**From:** Jean Fraser  
**To:** Swett, Lauren  
**CC:** Roncarati, Doug; Tarling, Jeff  
**Date:** 2/18/2014 4:10 PM  
**Subject:** RE: Rockland Ave Outfall

C-201

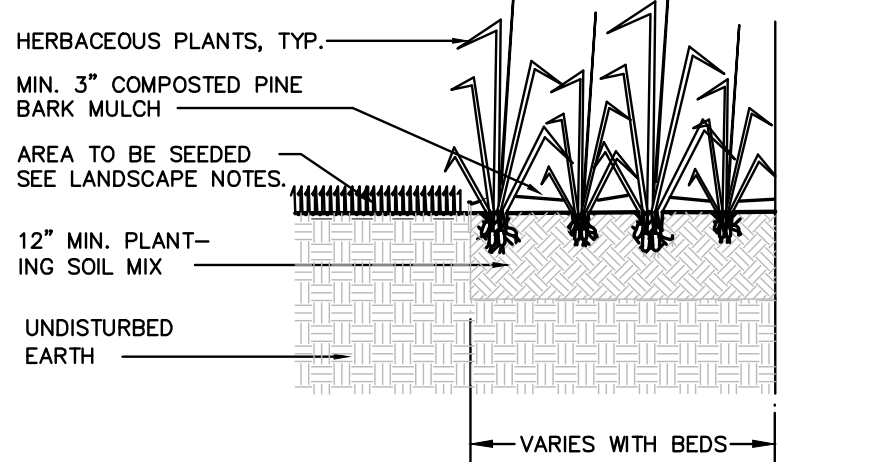
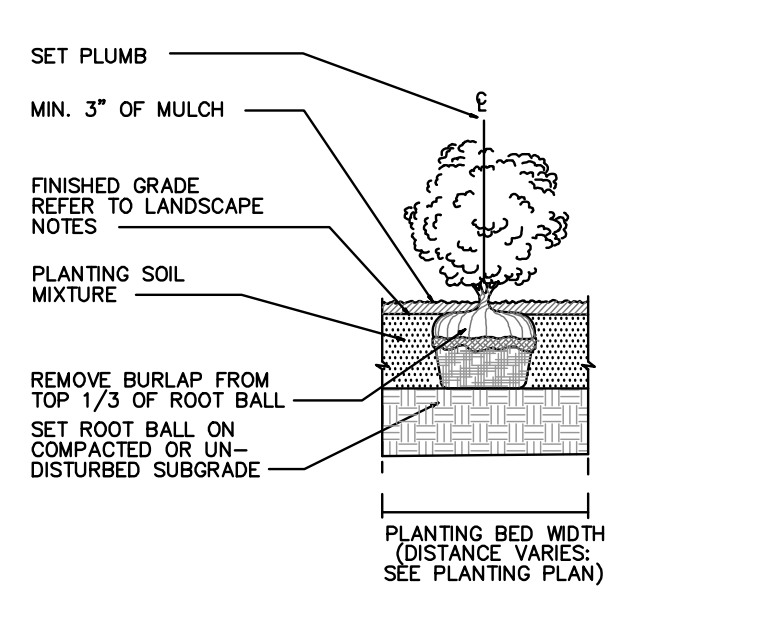
Why isn't there any landscaping shown where the wider paved area is being introduced (where does not exist now) in close proximity to homes and the trail?

Although I am waiting for Jeff to confirm his comments on the proposals, I would like either another site plan or the landscape plan to show just the final condition, with the trail shown and labeled and what is happening (landscape wise) around the new maintenance access and treatment unit (I know its underground but there will be disturbance and round man made features showing above ground I believe.)

ROCKLAND AVENUE OUTFALL
SITE PLAN & PROFILE,
SECTIONS

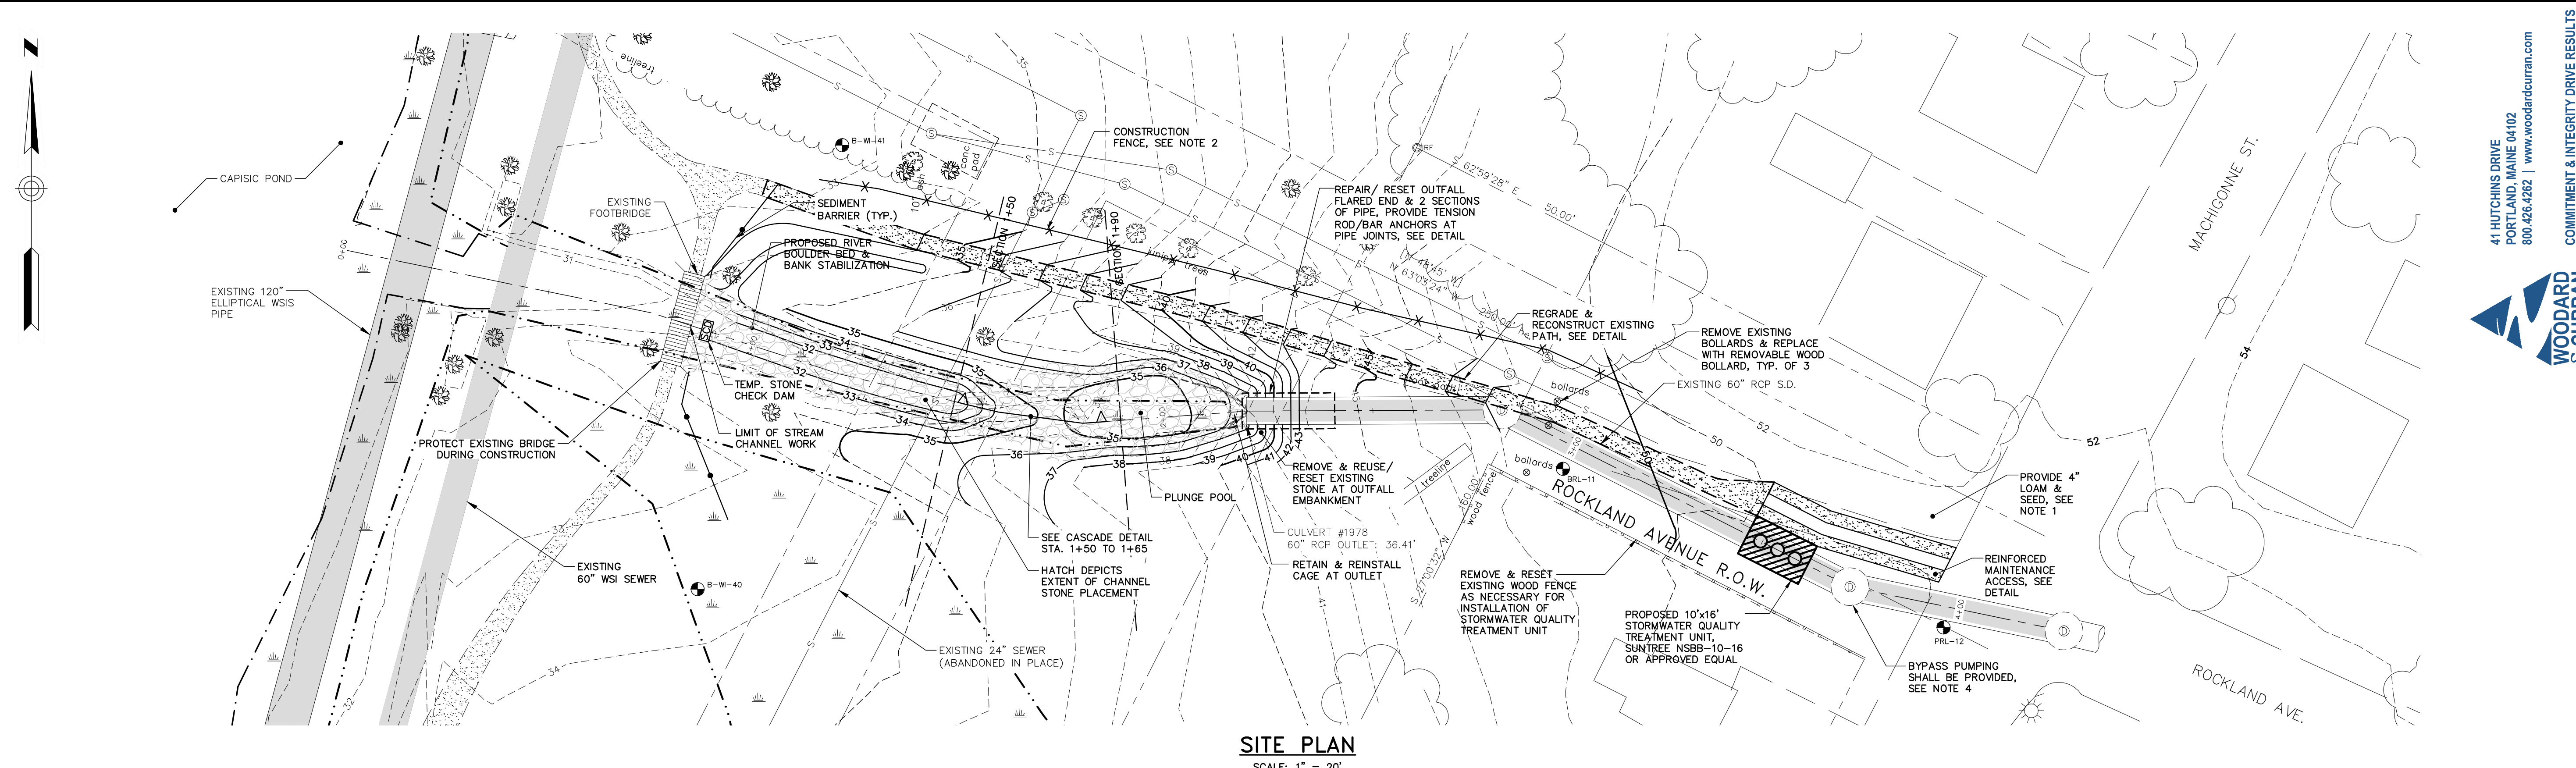
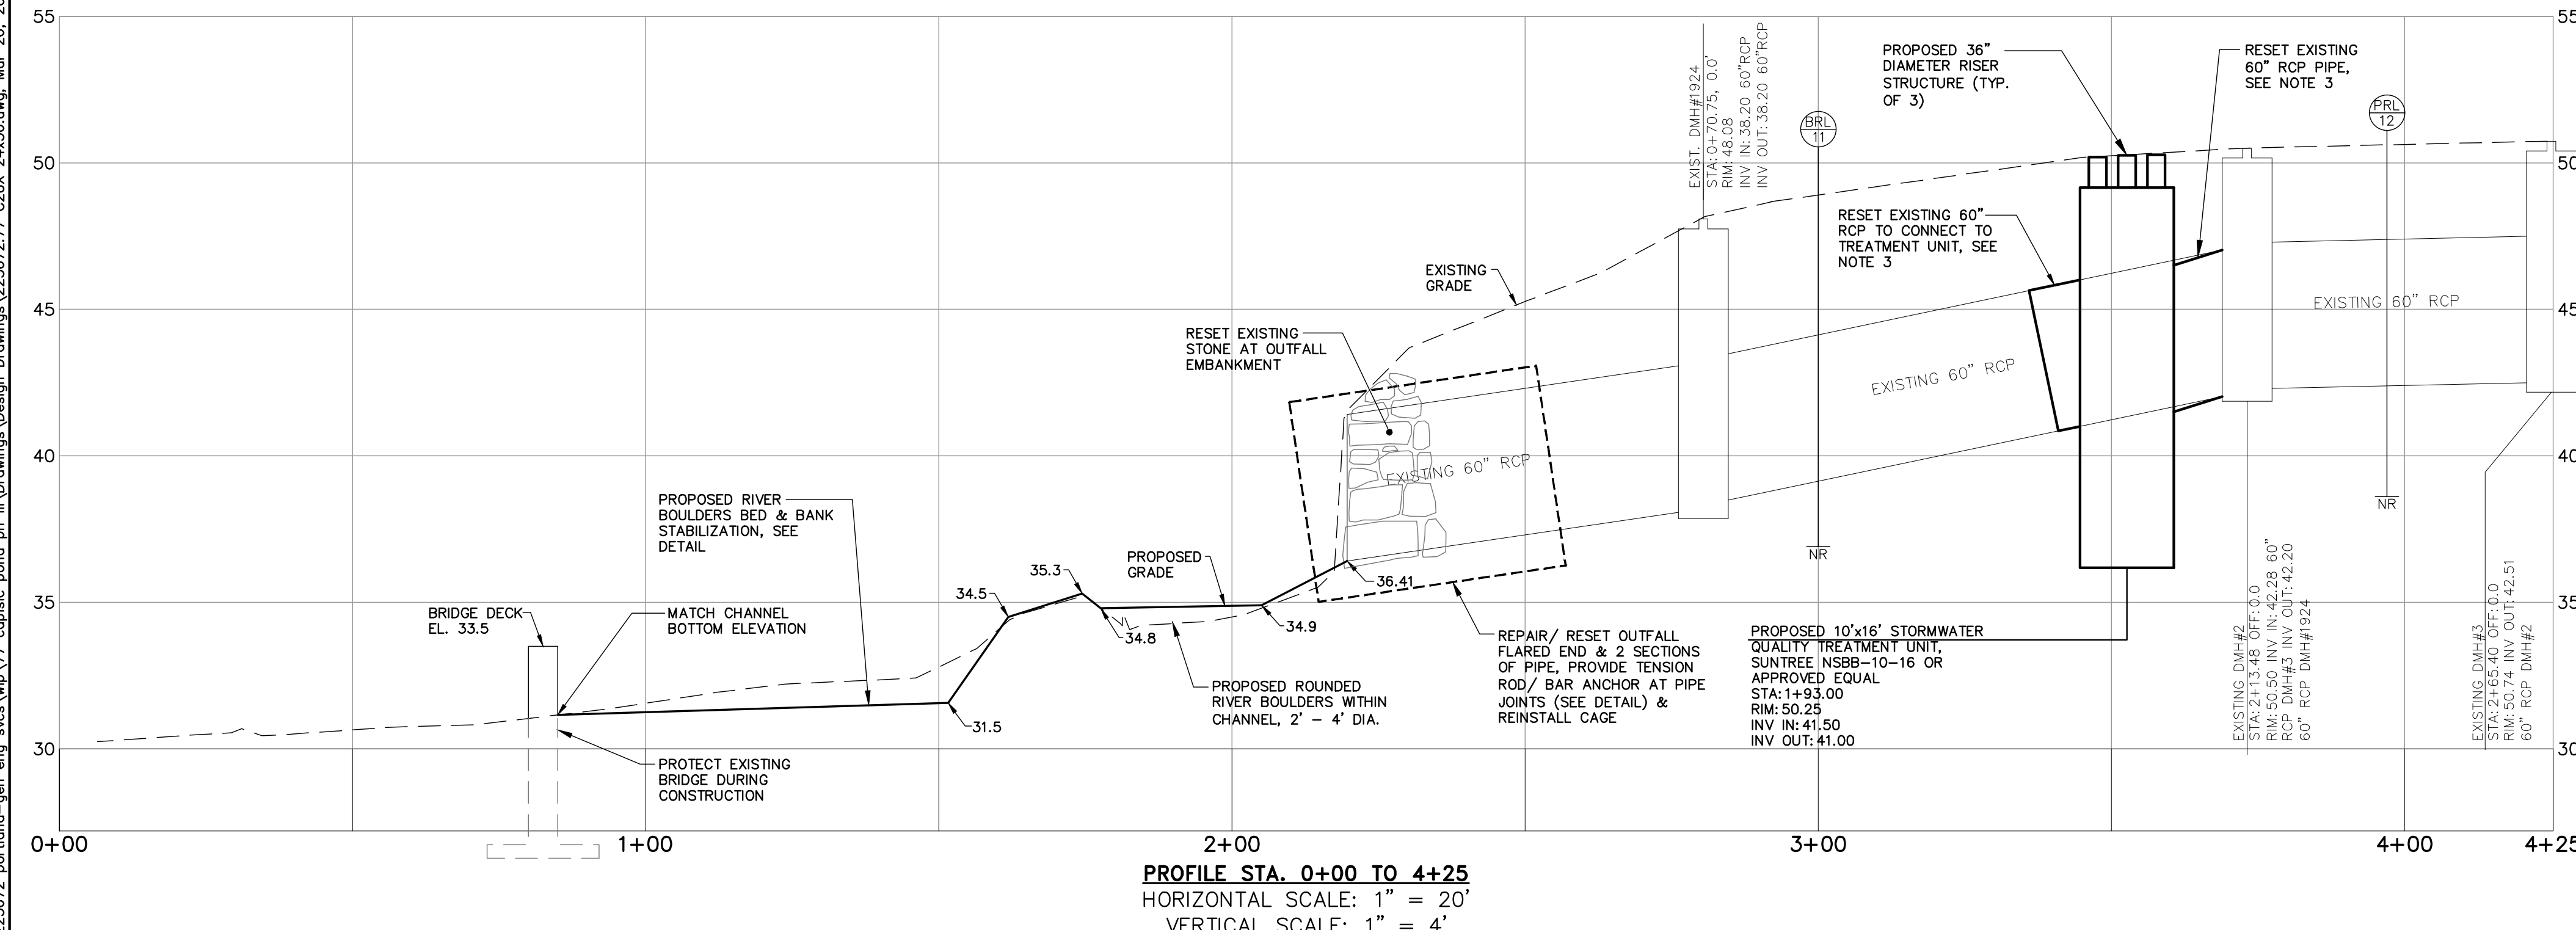
Section 3 of the application booklet, RTI- is there an updated "boundary page" (as mentioned); Since the access is going to be permanently upgraded, is some kind of easement or permission from abutters needed- the City's land is very close to the existing house and I would have thought there would be some restrictions on use of the land (DPS may have documentation so have copied Doug) The site plan is confusing as it shows existing, interim (temporary) and final all on one plan- so raises questions:

Presumably the reinforced maintenance access is permanent, so where will the trail be after its temporary location during construction?
